WEST SUSSEX COUNTY COUNCIL CONSULTATION

TO:	Arun District Council FAO: Michael Eastham
FROM:	WSCC - Highway Authority
DATE:	17 December 2021
LOCATION:	Central Wetland Area Hampton Park Toddington Lane Littlehampton BN17 7PL
SUBJECT:	LU/369/21/RES Approval of reserved matters following outline consent LU/47/11/ (amended under LU/182/15/PL) for the main on-site infrastructure at Hampton Park and encompasses: 1) the Central Wetland Area, 2) the main spine road and crossing structures & 3) the SUDs features.
DATE OF SITE VISIT:	n/a (desktop study undertaken)
RECOMMENDATION:	More Information Required
S106 CONTRIBUTION TOTAL:	n/a (SEE S106 AGREEMENT FOR OUTLINE CONSENT)

This is the WSCC County Highways (CHA) response to the above planning application for approval of reserved matters following outline consent LU/47/11/ (amended under LU/182/15/PL) for the main on-site infrastructure at Hampton Park and encompasses: 1) the Central Wetland Area, 2) the main spine road and crossing structures & 3) the SUDs features.

Typical Pile Reinforcement Section
Scale 1:20

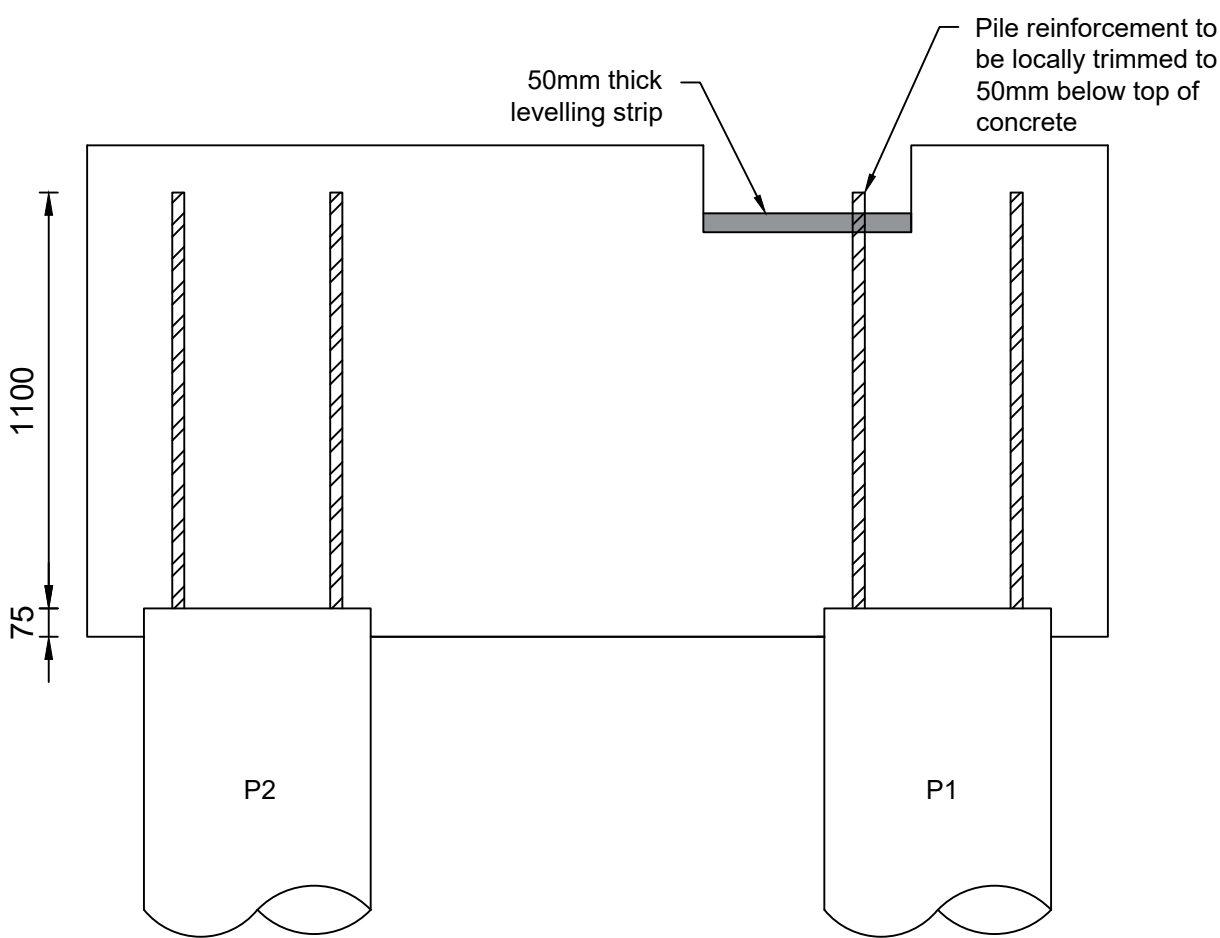
2. There's a drg. for the piles and piles caps (drg. 2231-001 & 002) that WSCC hasn't seen previously but wouldn't expect to see until the awaited Design and Check submission (which will also require approval) prior to construction.
